Consultation Response from KC, Highways Development Management		
2021/90207 Round Ings Barn, Round Ings Road, Outlane, Huddersfield, HD3 3FQ		
Erection of extensions and external alterations to existing dwellings and attached barn to form 4 dwellings; demolition of detached barn; erection of detached car port and change of use of land to form access and parking (Listed Building)		
Date Responded: 17/03/2021	Responding Officer: Mark Berry	Responding Ref: 1-46-11

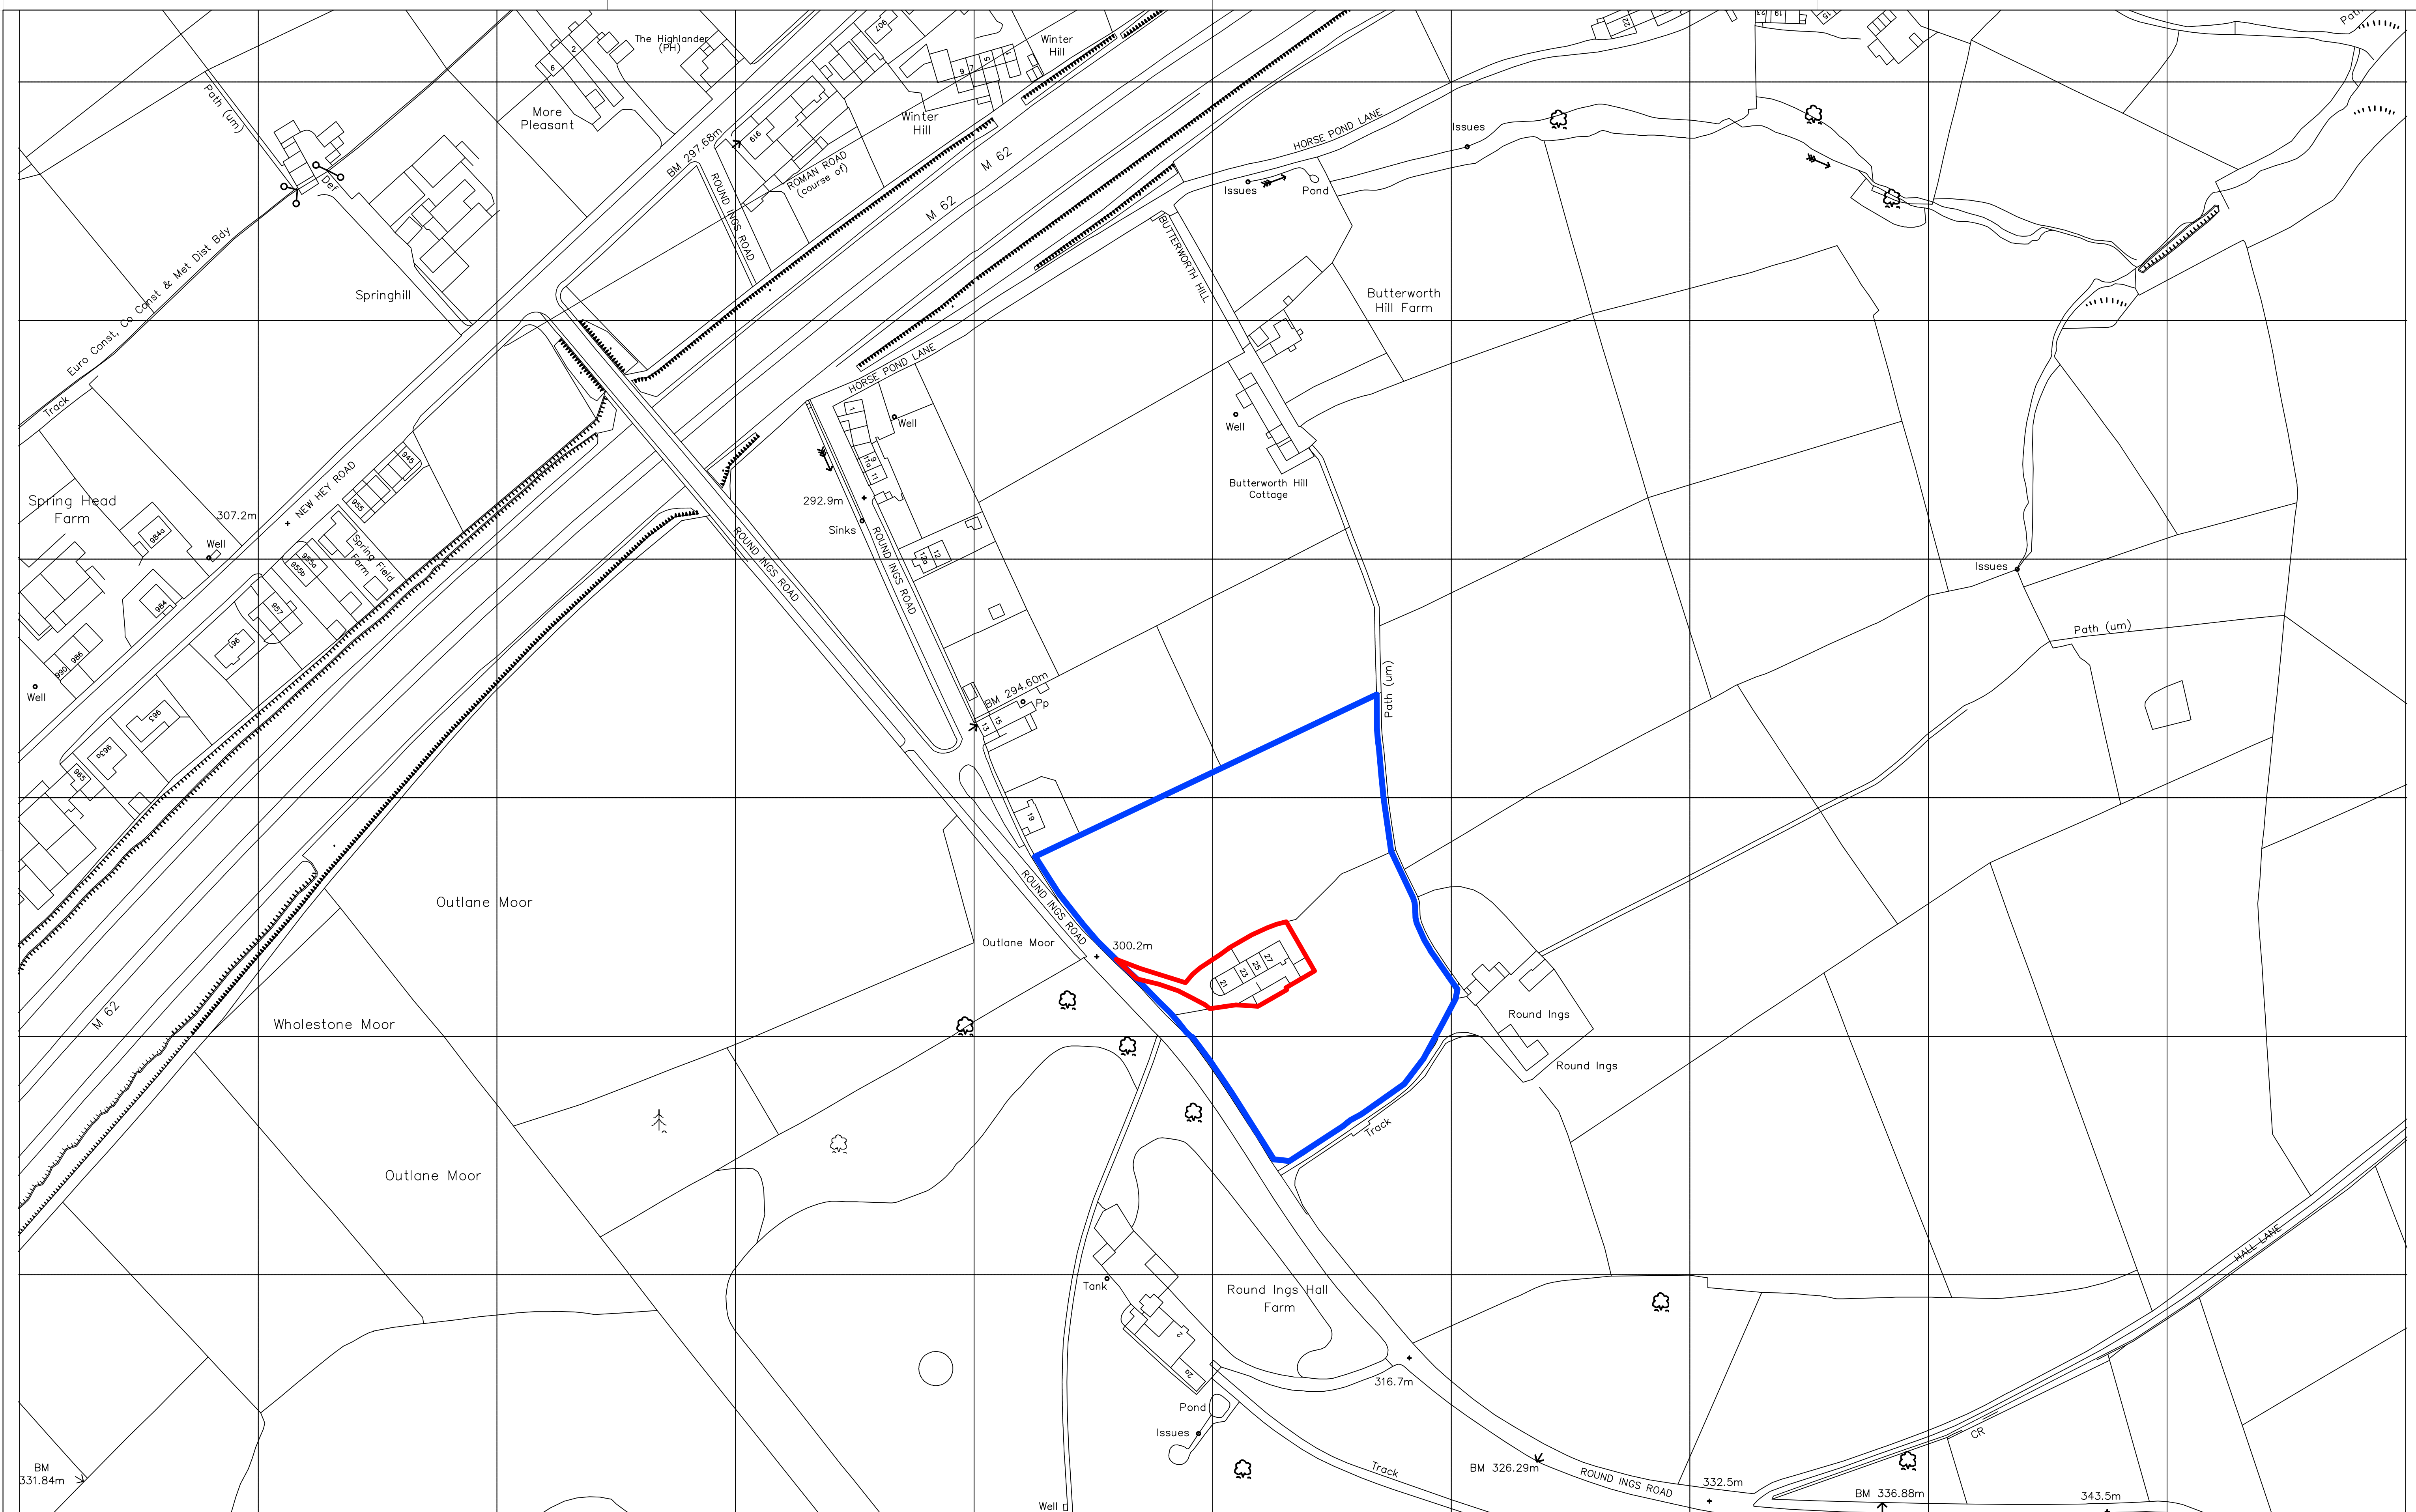
1, The sight lines at the site access on to Round Ings Road are incorrectly drawn. These should tie into the near side carriageway edge and not the centre of Round Ings Road.

2, The proposed gradients should be provided along the centre lines of the proposed access road and turning head.

3, The proposed works to construct the widened access road and turning head could undermine the existing wall/ embankment supporting Round Ings Road. Cross - sections should be provided to show the gradients between the access road and turning head and the wall to Round Ings Road to determine whether structures planning conditions will be needed.

4, The refuse vehicle swept paths should be for an 11.85m refuse vehicle.
